Application No: FP/136/21/PL
Site Address: Beachcroft Hotel Clyde Road Felpham PO22 7AH
Description of works: Re-modelling of existing swimming pool with re-clad elevations and private roof terrace over. This site is in CIL Zone 4 (Zero Rated) as other development.

Thank you for your internet representation made on 13th July 2021 which has been recorded as an objection with the comments as follows:

Proposed Roof Terrace Plan

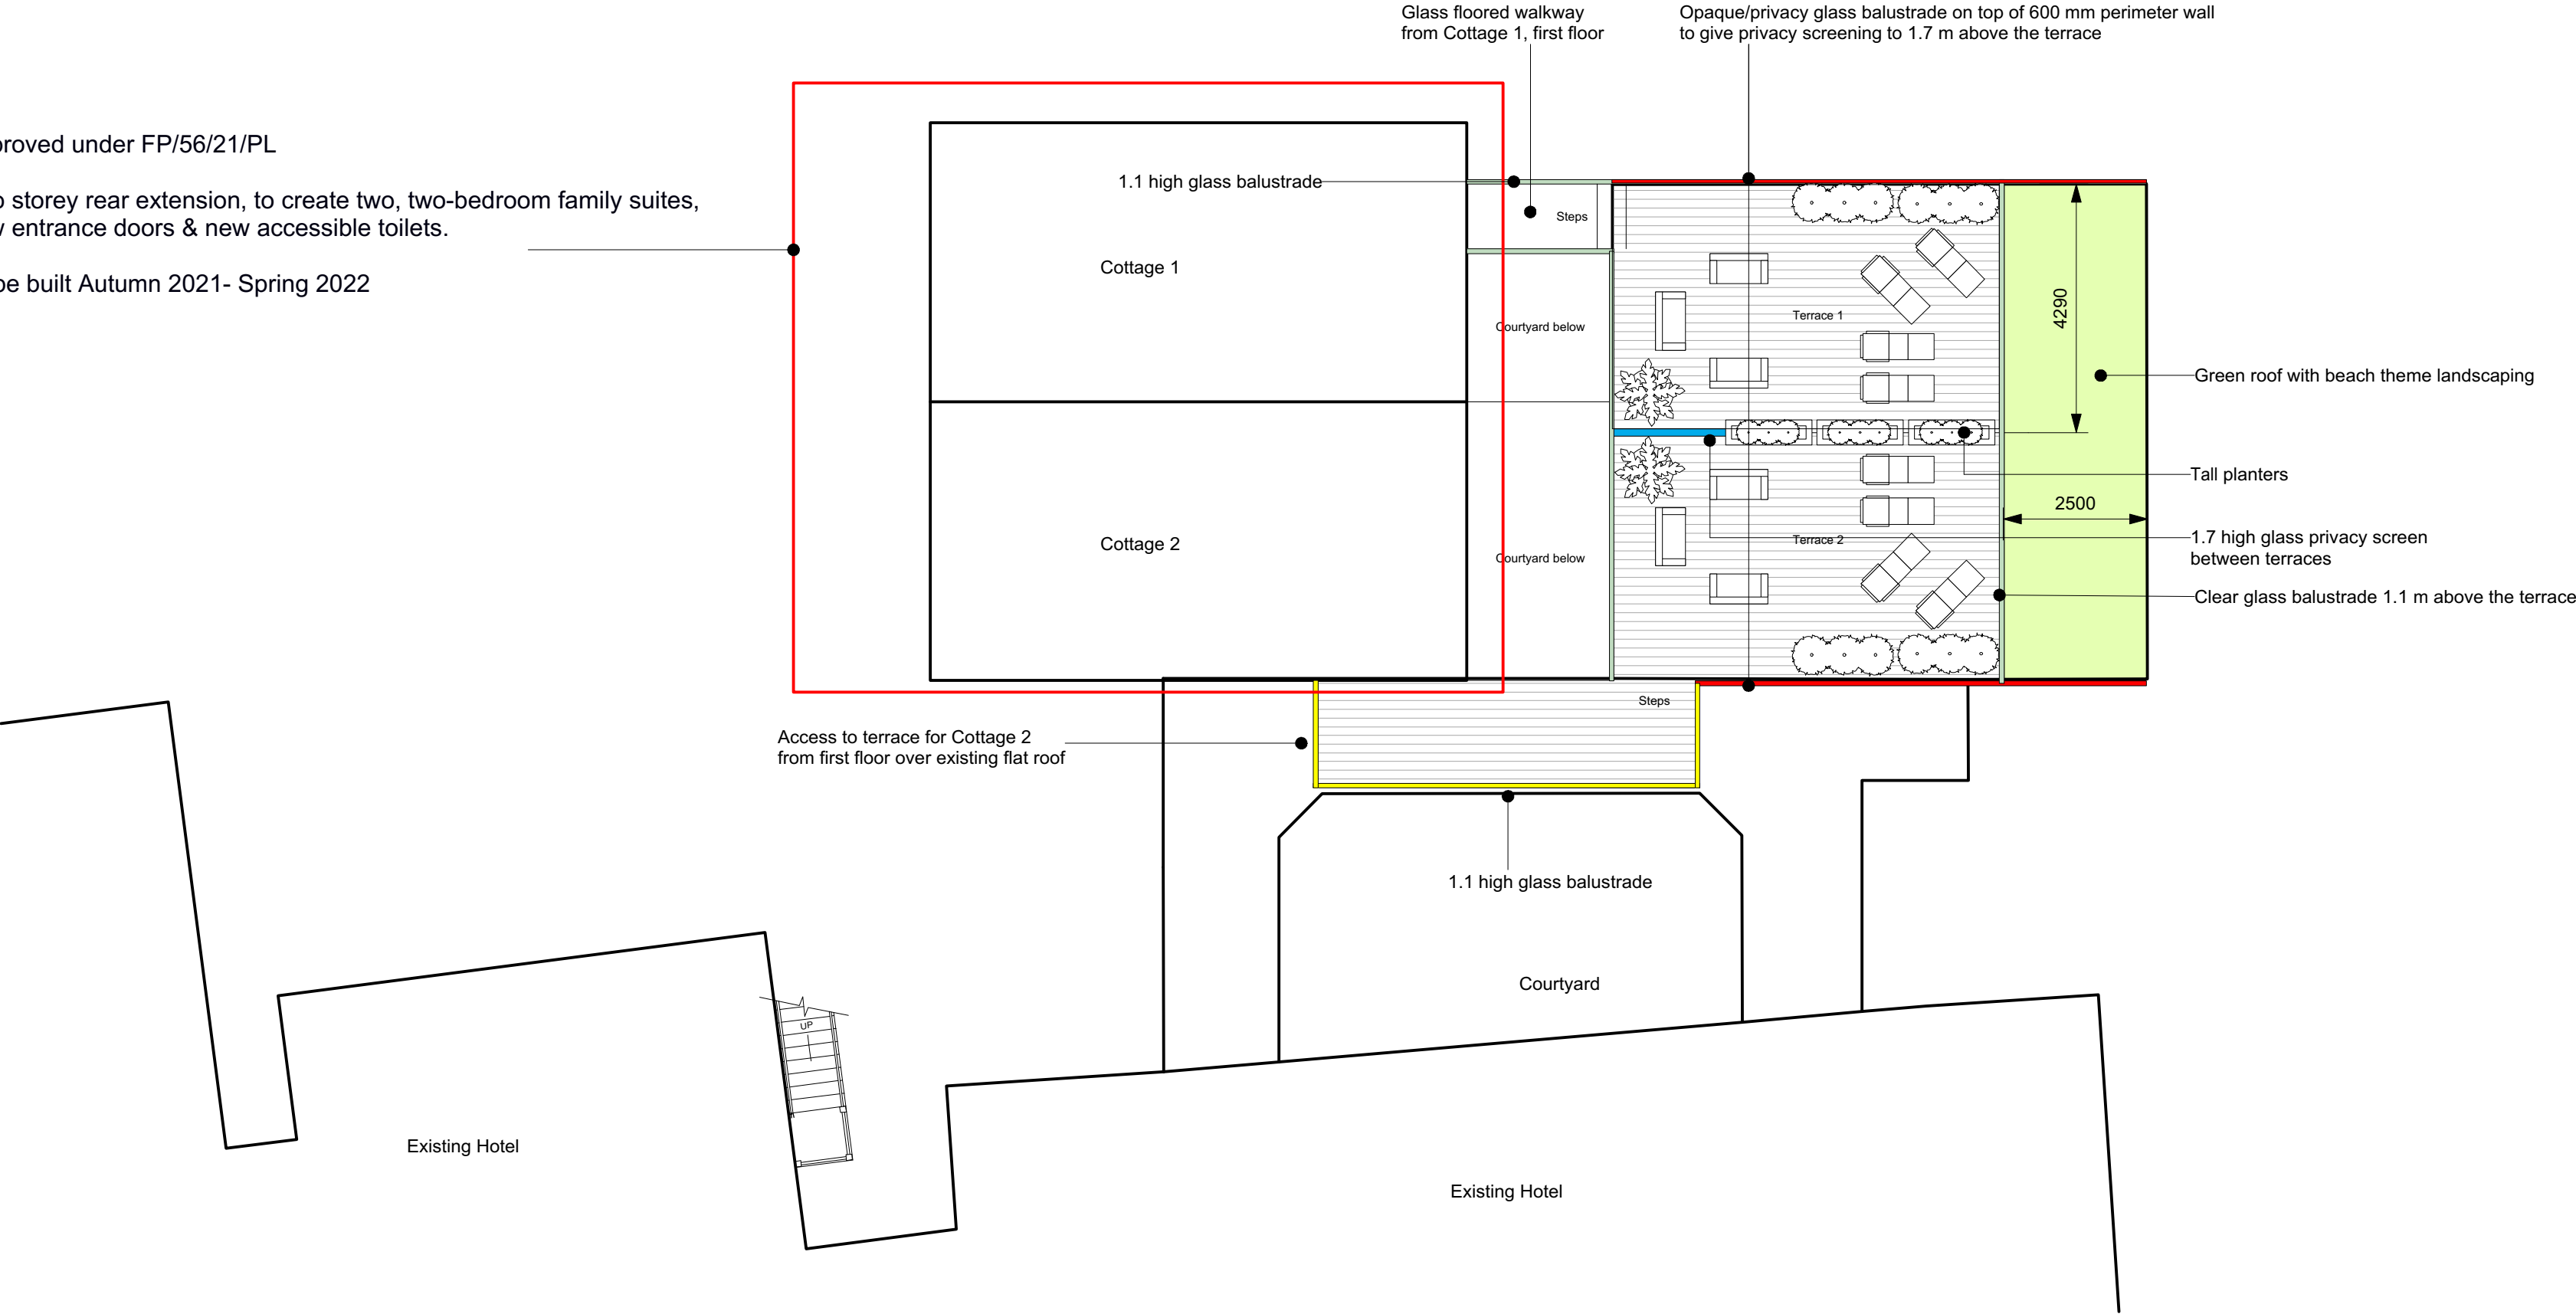
OVERLOOKING ASPECT OF TERRACED ROOF ON ADJOINING PROPERTIES - LACK OF PRIVACY
